Written Representation to the Examining Authority by Norton Disney Parish Council (Interested Party Reference Number: ██████████)

In connection with the Examining Authority's final first written questions ExQ1: 14 January 2026, Norton Disney Parish Council has concerns around questions Number LV.1.04 (directed to NKDC and LCC) and Number LV.1.05 (directed to the applicant, NKDC and LCC).

FIGURE NUMBER REV.
Figure 3-2B SHEET 3 01

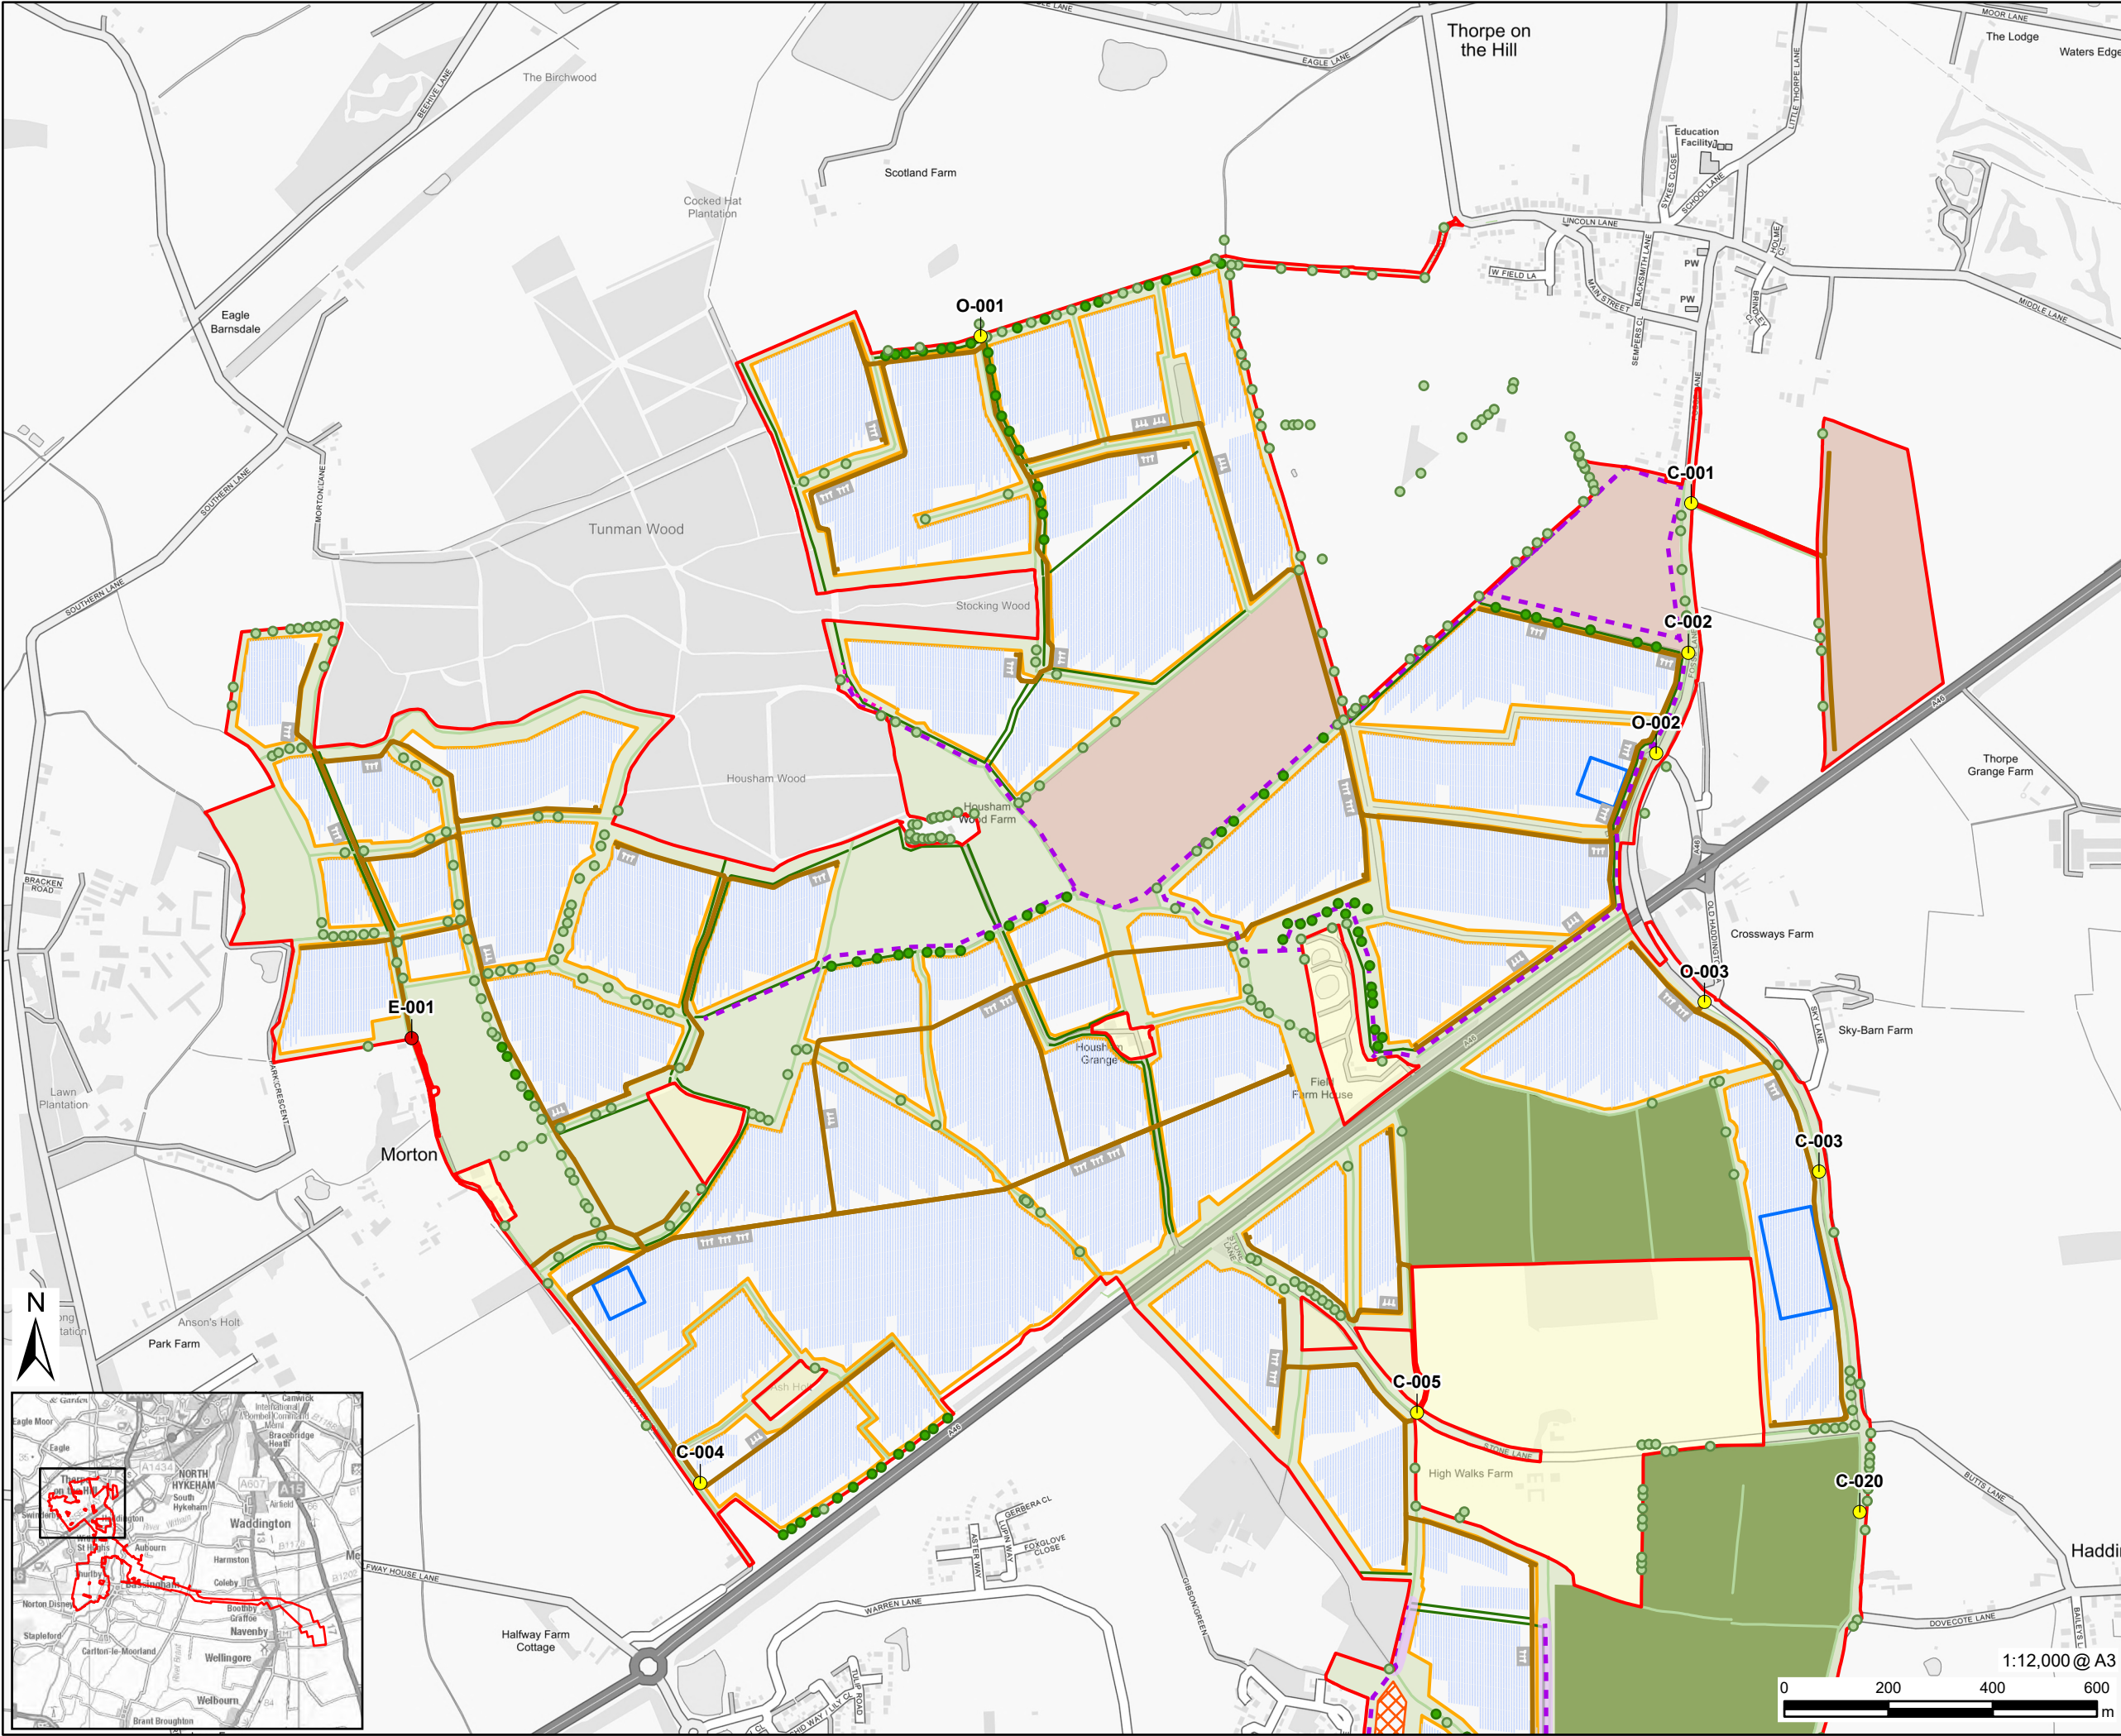
Norton Disney, of all the parishes affected by the application, has the least proportion (approximately just 3 per cent) of land given over to the proposed development. However, if the proposal is implemented, the visual impact for users of public rights of way (PRowS) by parish residents would be huge and would not be amenable to any mitigating measure suggested by the applicant. We refer to the single-track road, Clay Lane, which runs eastwards from the eastern margin of the parish into the areas shown in Sheets 7, 8 and 9 of the applicant's Land Plan, Document Reference EN010154/APP/2.1. Clay Lane carries little traffic but is used extensively by a very large proportion of our residents as a PRow for leisure, exercise and promotion of wellbeing by simple appreciation of this rural environmental asset. Along this PRow walkers frequently encounter wildlife including brown hares, foxes and deer and birdlife including barn owls, lapwings and skylarks. There are no roadside hedgerows whatsoever along the northern verge of Clay Lane for its entire length from the point at which it enters the areas of the Land Plan referred to above to the entrance of the track to Church Farm, more than a mile further on. As a consequence, there are currently unimpeded views across agricultural land as far as the eye can see in the area referred to in LV.1.05 b), which the ExA identifies as "field 62 on sheet 8 of Figure 7.15-1 in the FLEMP [Appendix A in AS-101]" (see image below, View from point O-007 etc.)

Norton Disney Parish Council is of the opinion that hedgerow planting along the length of Clay Lane with the objective of mitigating the visual impact of the proposed project would be counterproductive as hedgerows would themselves, just as the installations proposed by the applicant, destroy the visual and recreational amenity currently enjoyed by our residents. We are unable to suggest any alternative mitigating measure.

In LV.1.05, directed to the applicant as well as NKDC and LCC, the ExA questions the effectiveness of the proposed roadside screen planting and notes its own observation made while undertaking its unaccompanied site inspection 1 (USI 1) that throughout the area of the proposed development all roadside hedgerows appear to be subject to managed pruning, resulting in hedgerows in the winter period being around 1.5m to 2.0m in height above carriageway level. The ExA asks in LV.1.05 b) “If the proposed roadside hedgerow planting was to be pruned in the manner observed by the ExA during its USI1, would those hedgerows provide effective screening for the proposed development? For example would the proposed array area occupying field 62 on sheet 8 of Figure 7.15-1 in the FLEMP [Appendix A in AS-101], adjoining Clay Lane west of Bassingham and east of Norton Disney be effectively screened by the proposed roadside hedgerow planting?” The opinion of Norton Disney Parish Council is that hedgerows of 1.5m to 2.0m in height would not provide effective screening for the proposed development and that hedgerows any greater in height would be profoundly obtrusive in this environment.
